From: Hill, Grace <Grace.Hill@e-lindsey.gov.uk>
Sent: 18 June 2026 12:59
To: Niland, Mark
Cc: _planningadvice
Subject: RE: H14-0083-26 - Ecologists comments

H14-0083-26 - Kendall Grove

From: Adam Jagger <adam.jagger@ashwoodhomes.co>
Sent: 17 June 2026 12:25
To: Niland, Mark <Mark.Niland@sholland.gov.uk>
Subject: H14-0083-26 - Ecologists comments

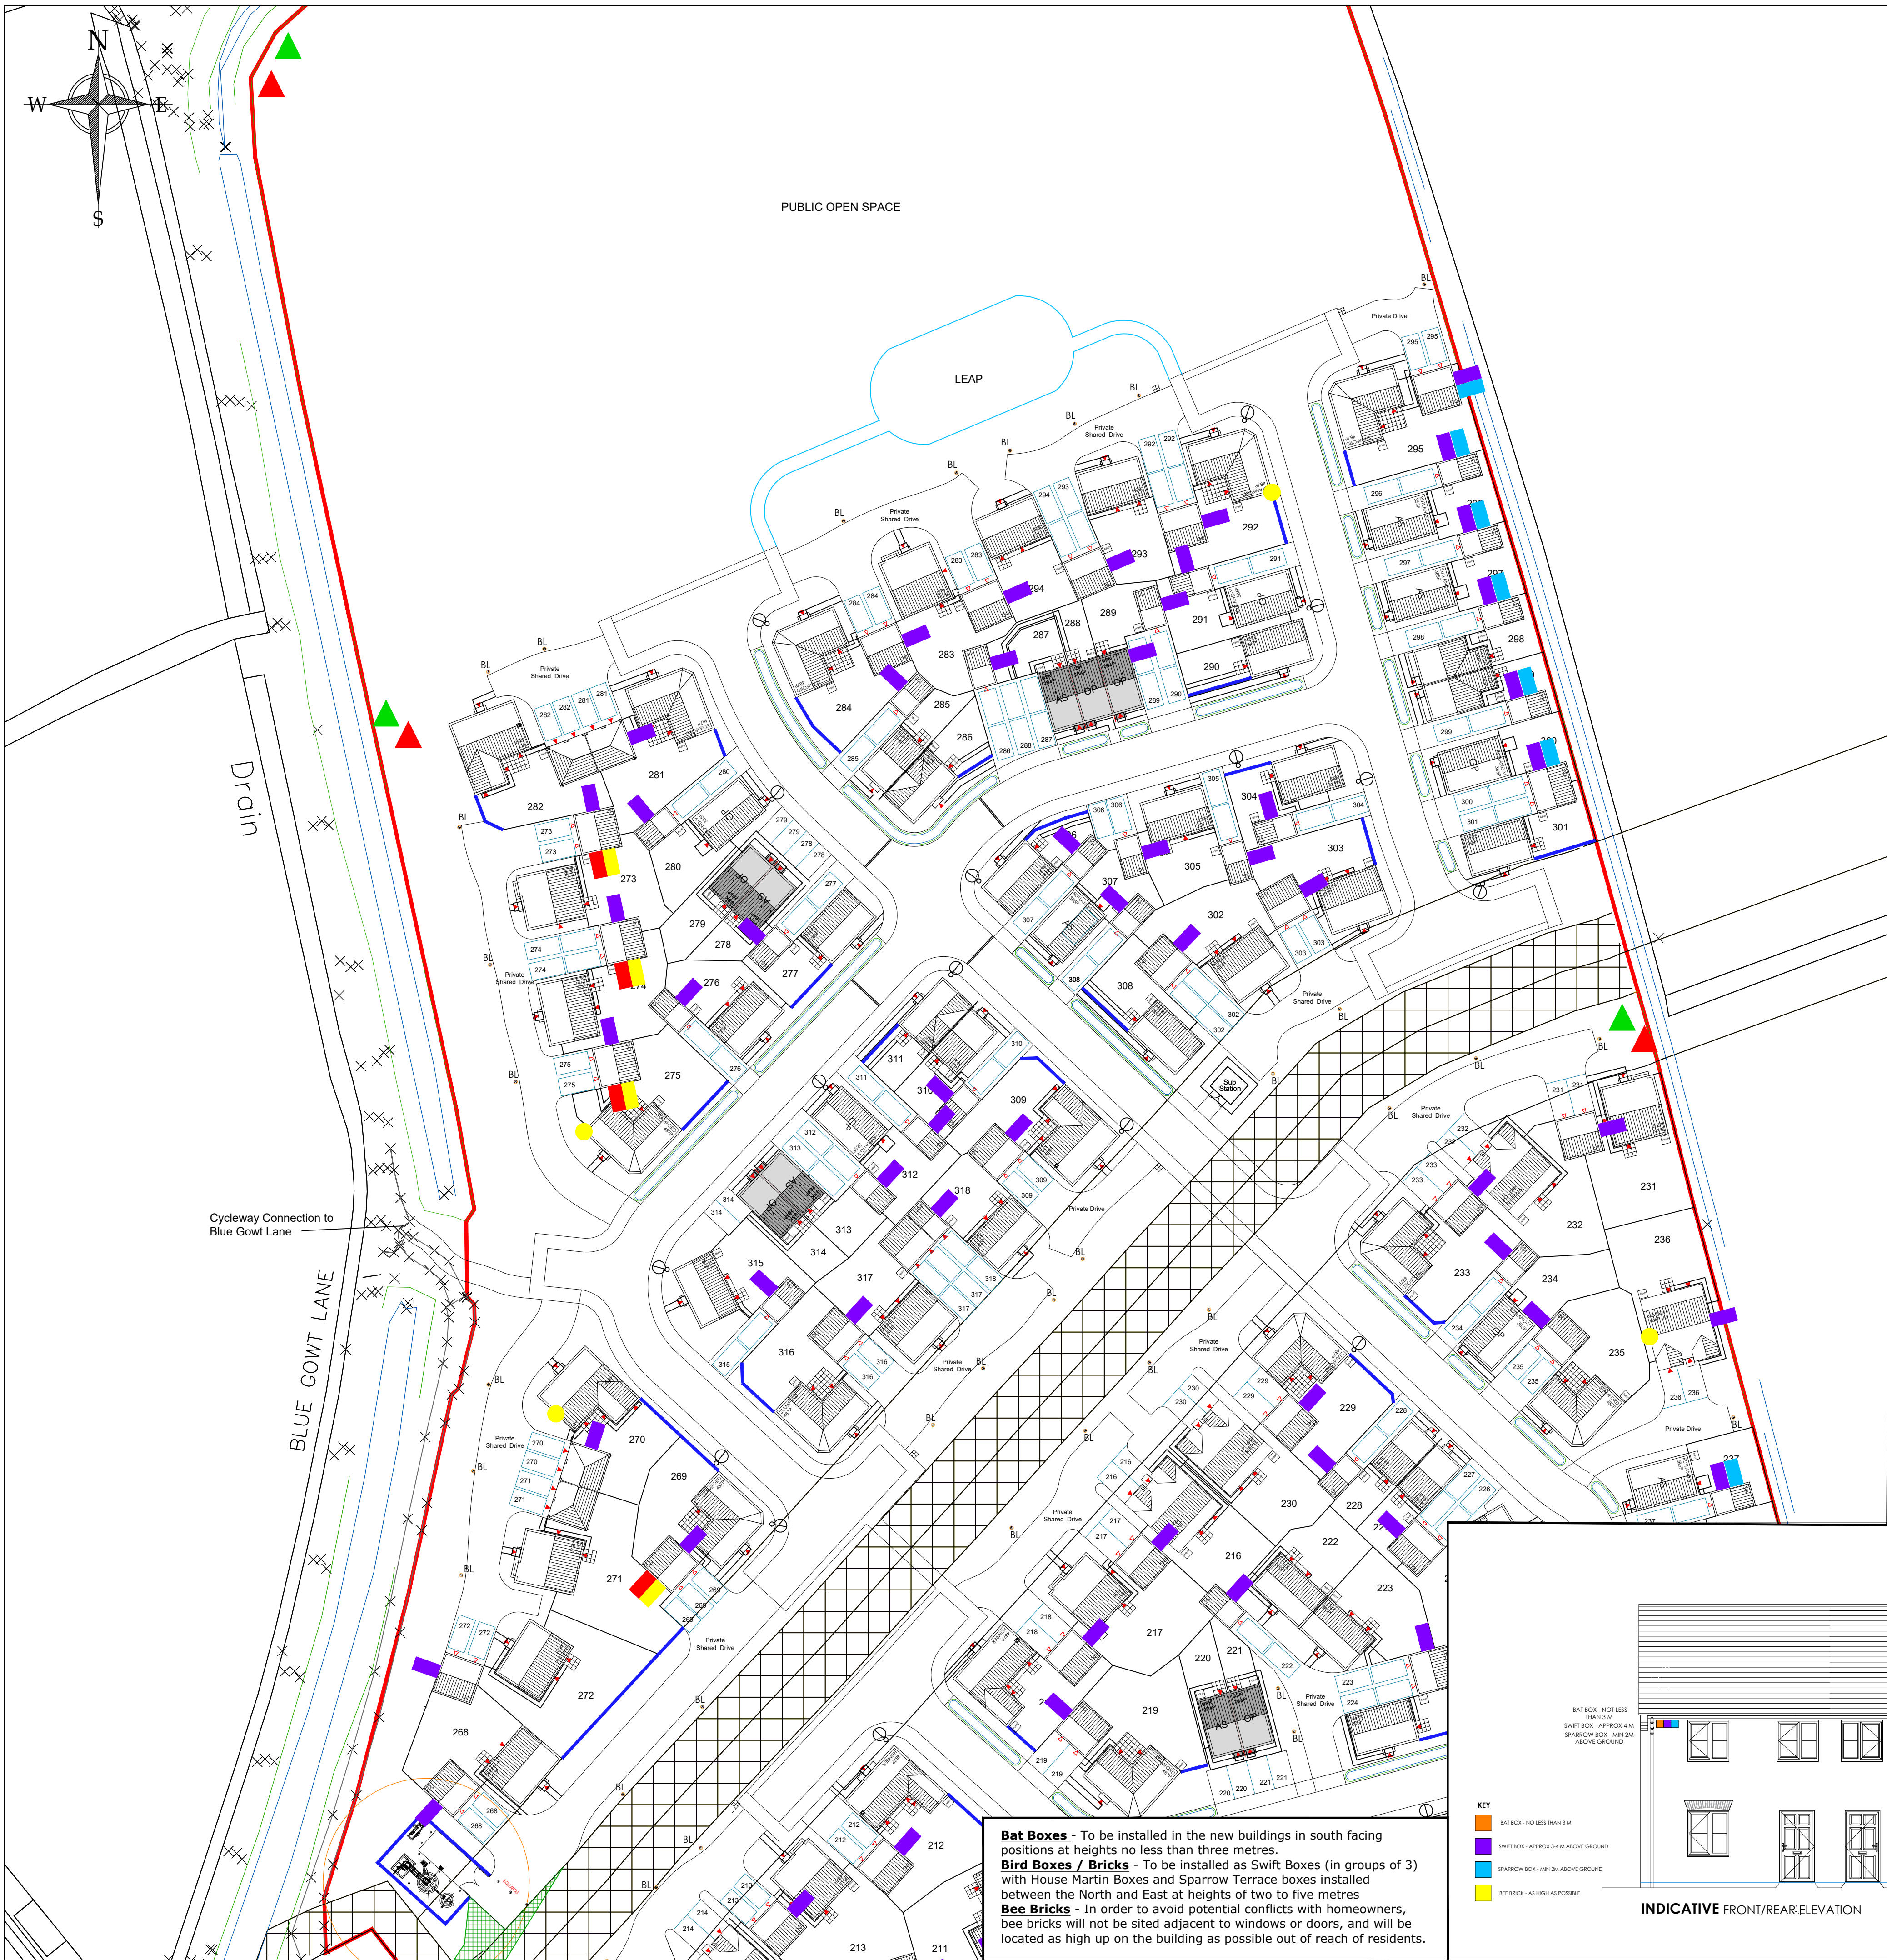
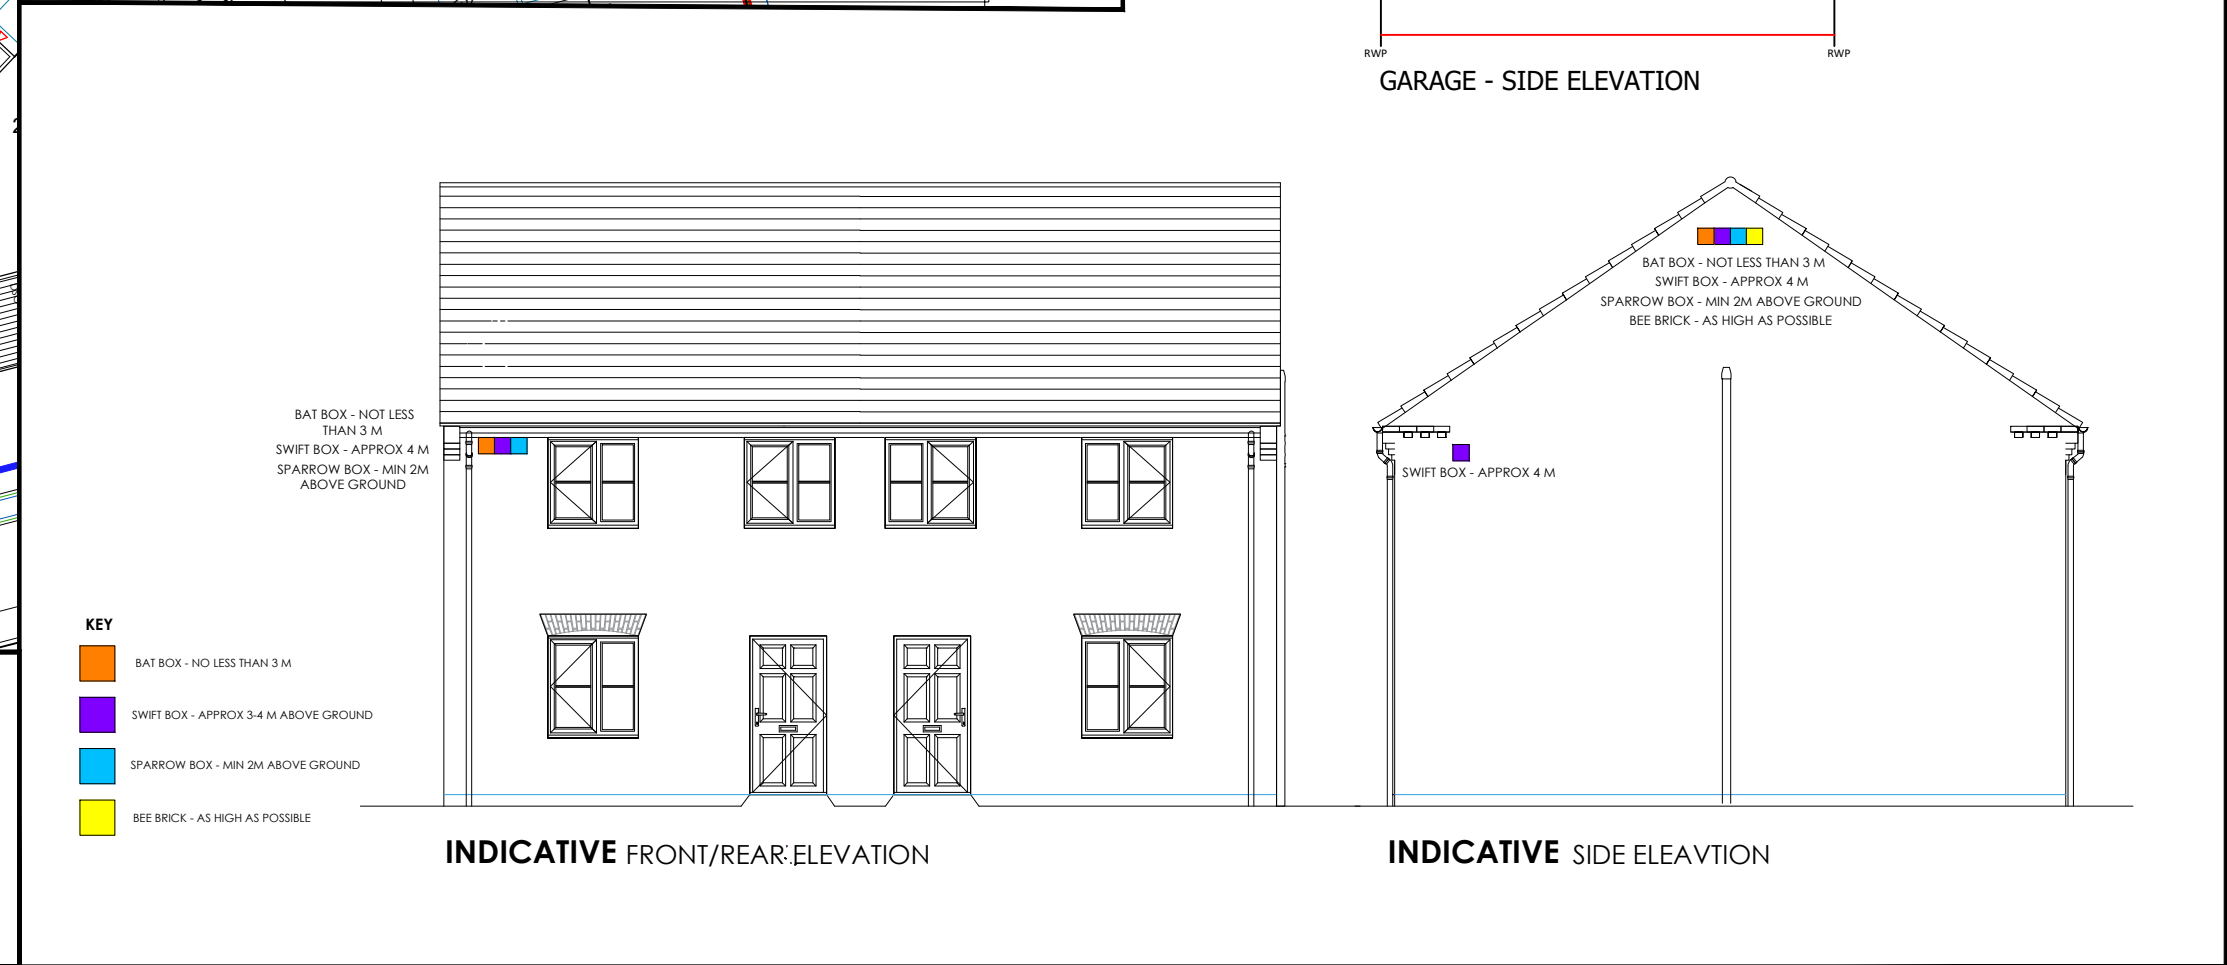
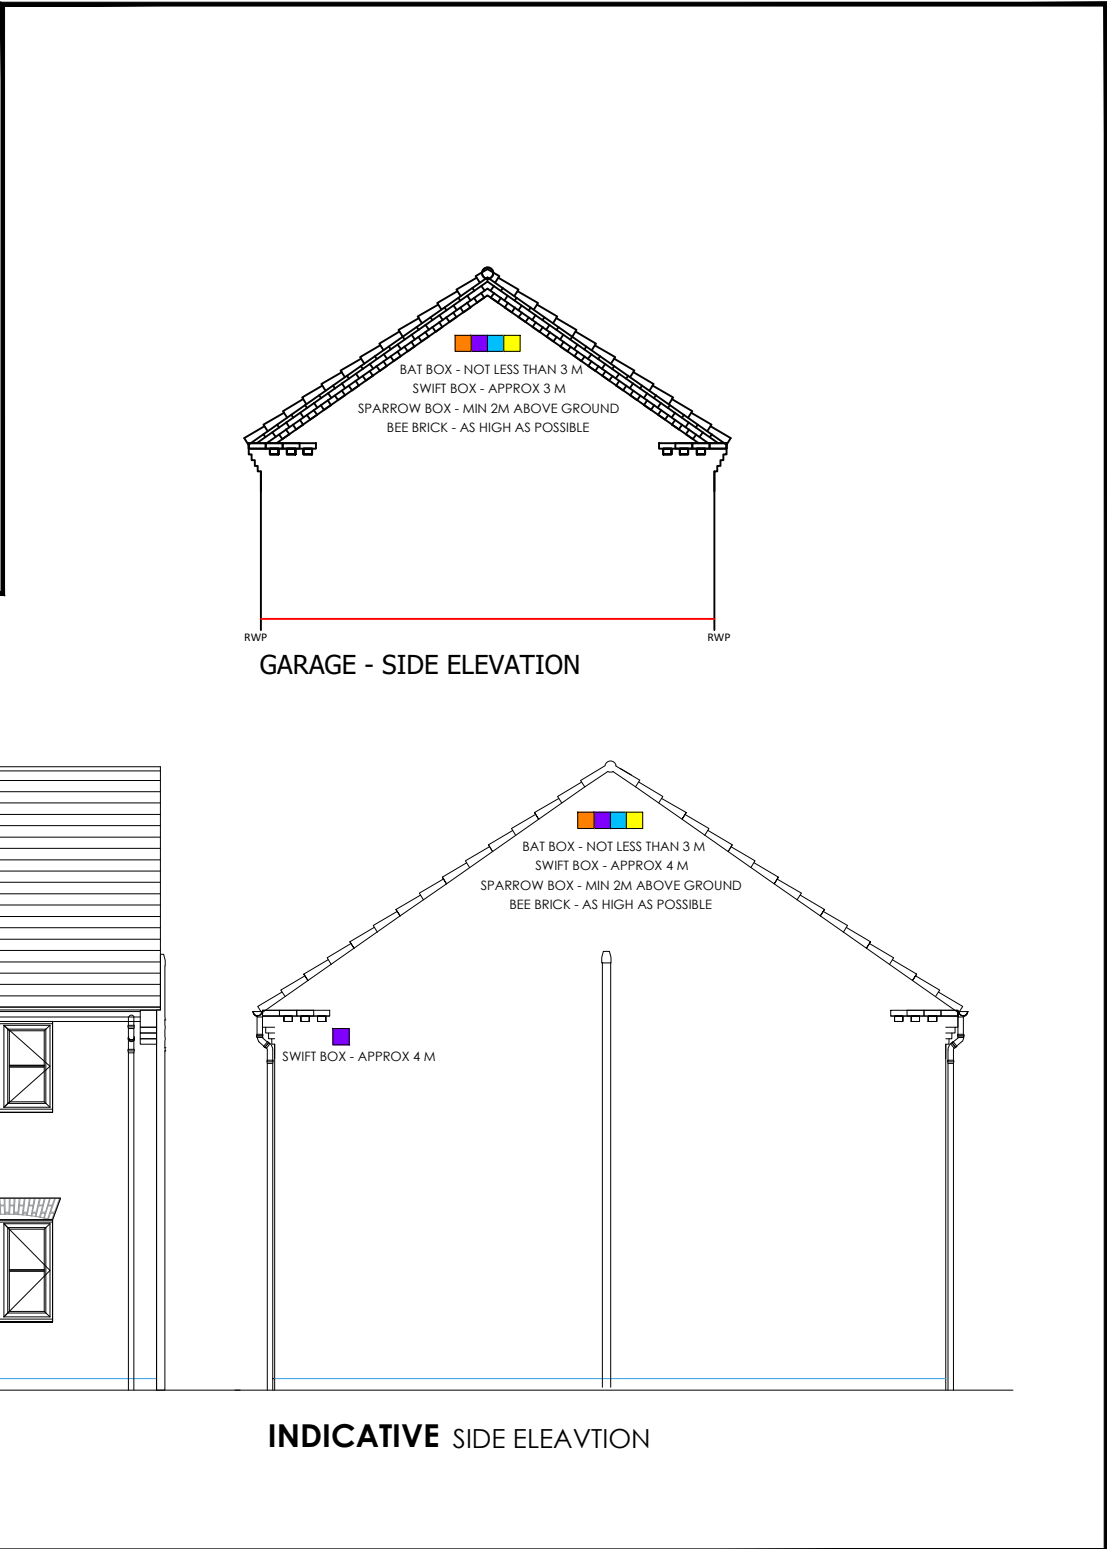
Thank you for sending this through. Having reviewed the amended Biodiversity Management Plan for the site, I am now satisfied that the proposed enhancements will be appropriately located. While the enhancements will not be integrated into the external fabric of the building, the applicant's ecologist has confirmed that the materials are durable and weatherproof, and therefore should have a relatively long lifespan. We also welcome the increased provision of bird boxes onsite, which will help mitigate potential losses should any become damaged over time. On this basis, we are now satisfied with the ecological provision for the site and support the application.

The updated report confirms that Bird Nest Boxes will be installed at a height of at least 4m from the ground (at the eaves or apex of gables).

Our ecologist has also increased the number of swift boxes to 12no in order address the officer concerns over longevity, and clarified that the specified units are constructed from durable, weatherproof and predator proof materials and are expected to last a considerable length of time.
